**Re: MAXWELL UNDERGROUND COAL MINE OPTIMISATION MODIFICATION APPLICATION –
SSD 9526 (Mod 2)**

This is a joint submission by Coolmore Australia and Godolphin Australia. We appreciate the opportunity of commenting on this modification application. While our studs are well known to you and the Department, background information on both is attached to our submission.

Figure 5 - Indicative Underground Mine Plan

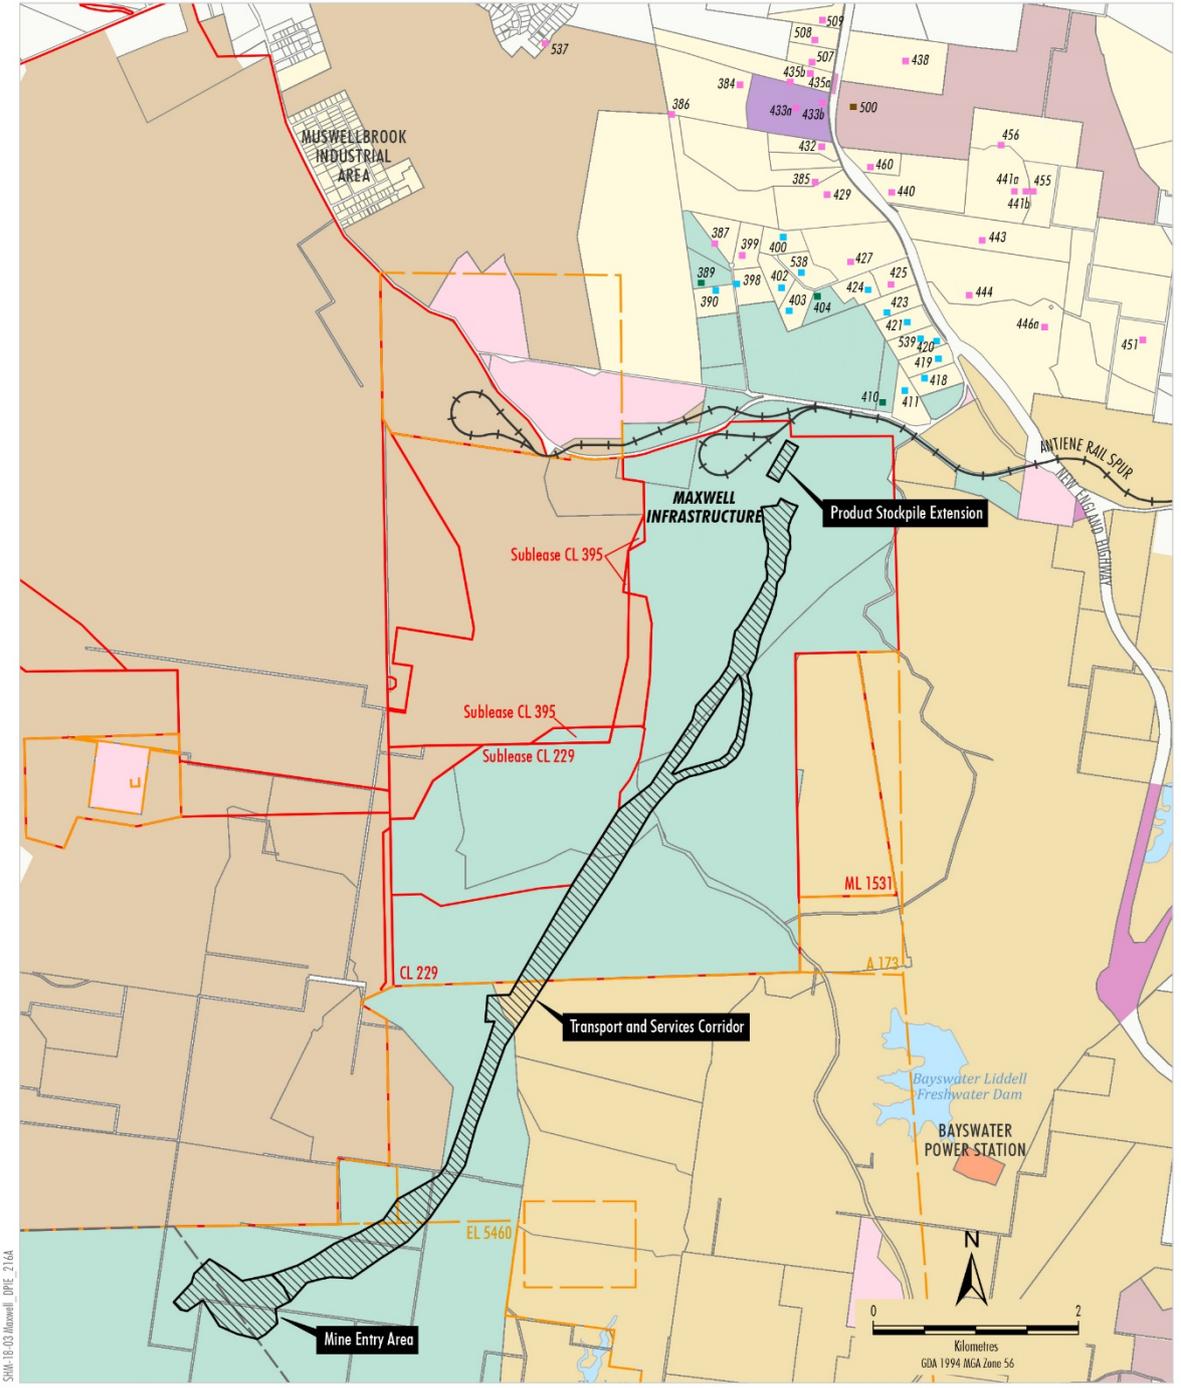
8. Water expert advice, which we have jointly commissioned, is represented in detail in the HTBA submission.
9. This modification seeks to significantly reduce the "buffer" distance from the predicted zone of subsidence to the Hunter River and Saddlers Creek by 23 % and 65% respectively.

10. It is our view that this is not only a significant increase in the potential risk to those water sources, but an extremely important issue which is inadequately assessed. It is also our view that it represents a departure from one of the limiting determinations for the approval for the mine.

15. The appropriate step we suggest is for the mining plan to be amended so the shafts do not extend any closer to the Hunter River, and Saddlers Creek than as originally approved. The reduction in distance to the Hunter River and Saddlers Creek is a direct result of the mine plan change and would be entirely preventable by changing the extraction plan and reducing the length of some longwall panels.

- b. Maxwell present options for its mine and extraction plan which reduce the length of relevant longwall panels to prevent increases of any subsidence risks to the Hunter River and Saddlers Creek, nearby roads and stud farms. Those longwall shafts should not go closer than those as originally approved as part of the mine plan originally proposed.

Figure 7 - Southern Receiver Locations

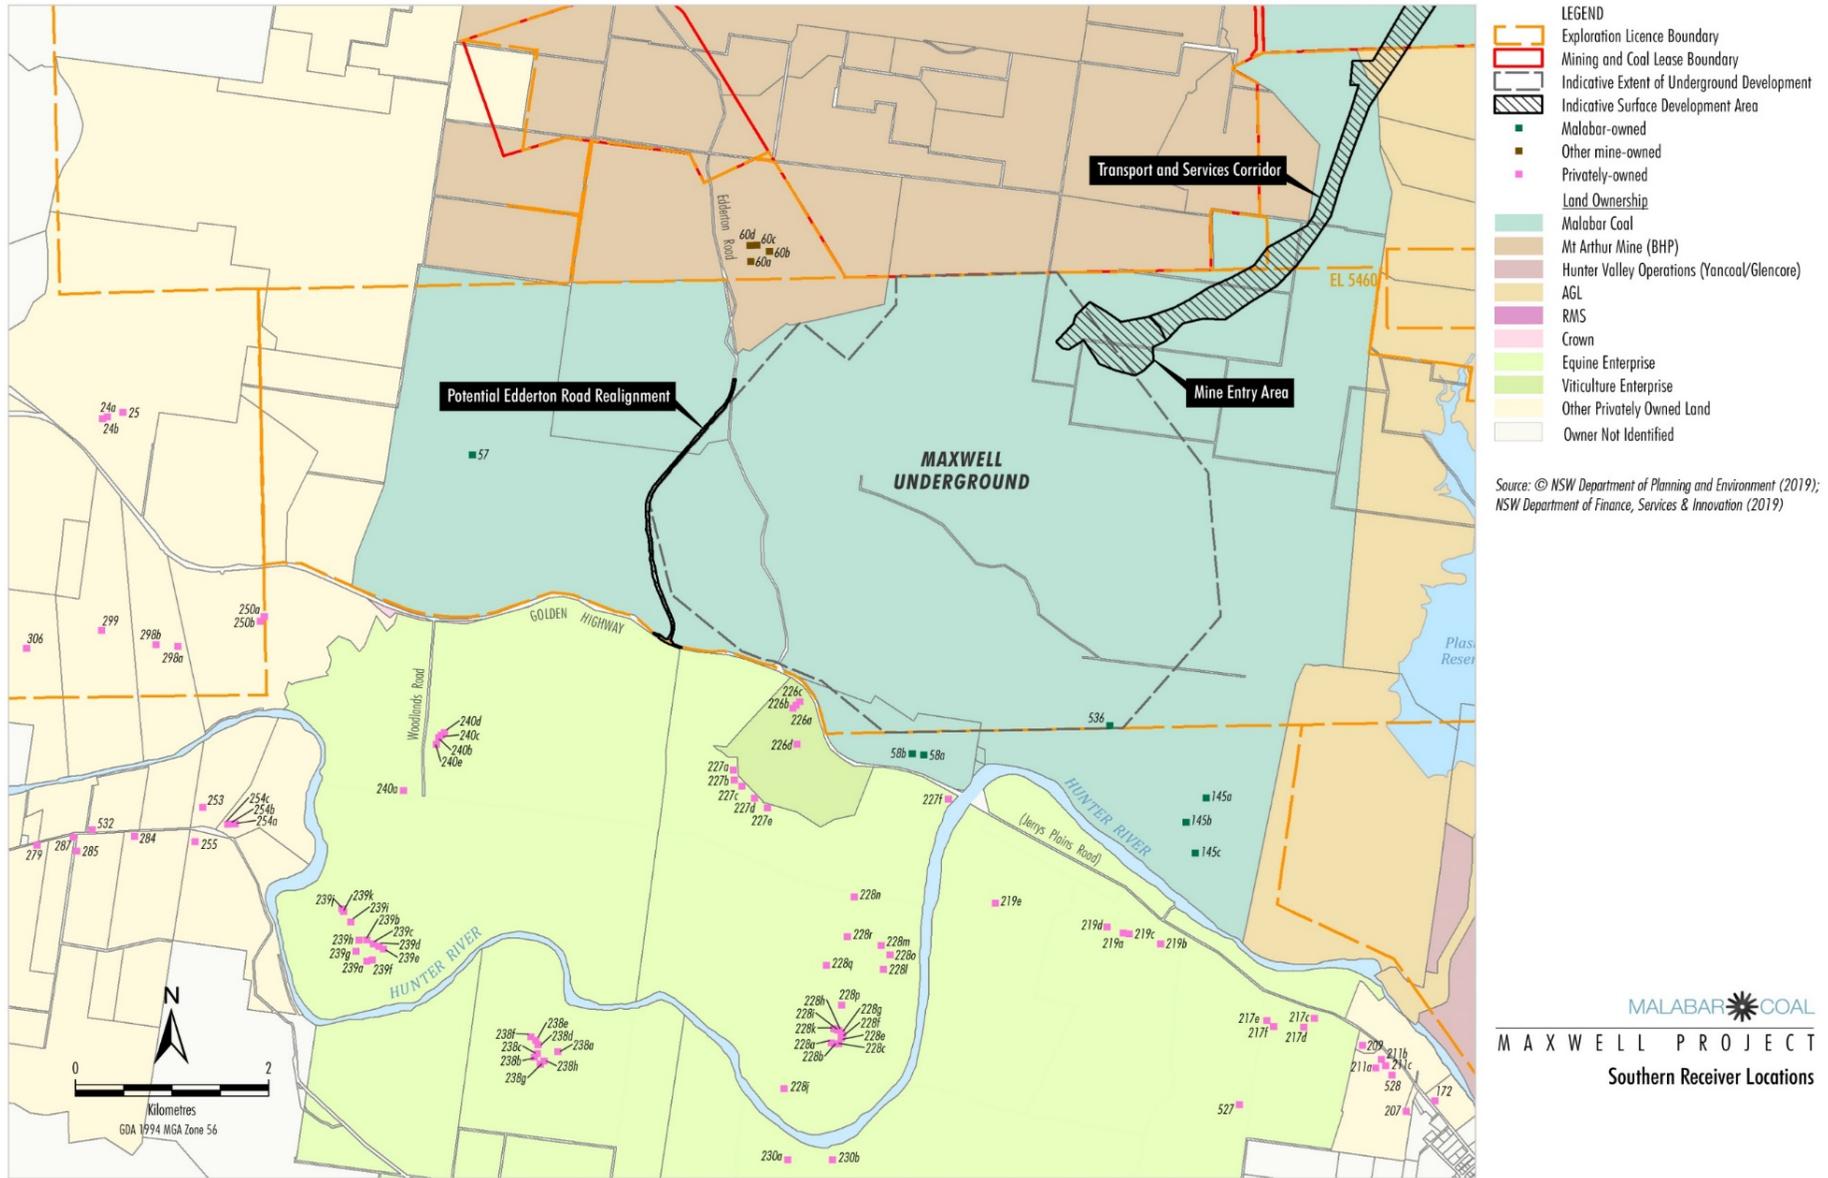
22. It is unusual therefore that Maxwell in its Mod2 proposal has not undertaken any modelling on sensitive noise receivers on the Godolphin Woodlands property. This is not in keeping with the original consent considerations and conditions, or the Commission's determination.

- a. For example, receiver 253 (NE Ray) which has been modelled. That property is situated across the river from Woodlands, further away from the Vent shaft site.

- b. The northern most residences on Woodlands are clearly closer than receiver 253 to the Vent shaft pad and have not been modelled (See Map showing modelled receivers is on page 3 of Appendix G Noise Assessment).
- 24. The table of results (Noise Assessment page 9 Table 5) show that distance is not the only factor and topography plays a big part in noise impacts.
 - a. For example, if one looks at receiver 58a (which is closer than receiver 228r) the table shows no impacts detected at 58a but there are some increased noise results at 228r which is further away.
- 25. Again we are of the view that these noise assessment issues are important matters, and to ignore them is against the import and scheme of consent provided by the Independent Planning Commission.

- 26. We submit that:
 - a. revised noise/blasting modelling be completed to include the assessment of impacts at Godolphin Woodlands (using the same sensitive noise receivers assessed as part of the original Maxwell underground mine applications particularly sensitive receivers 240 a- e) .
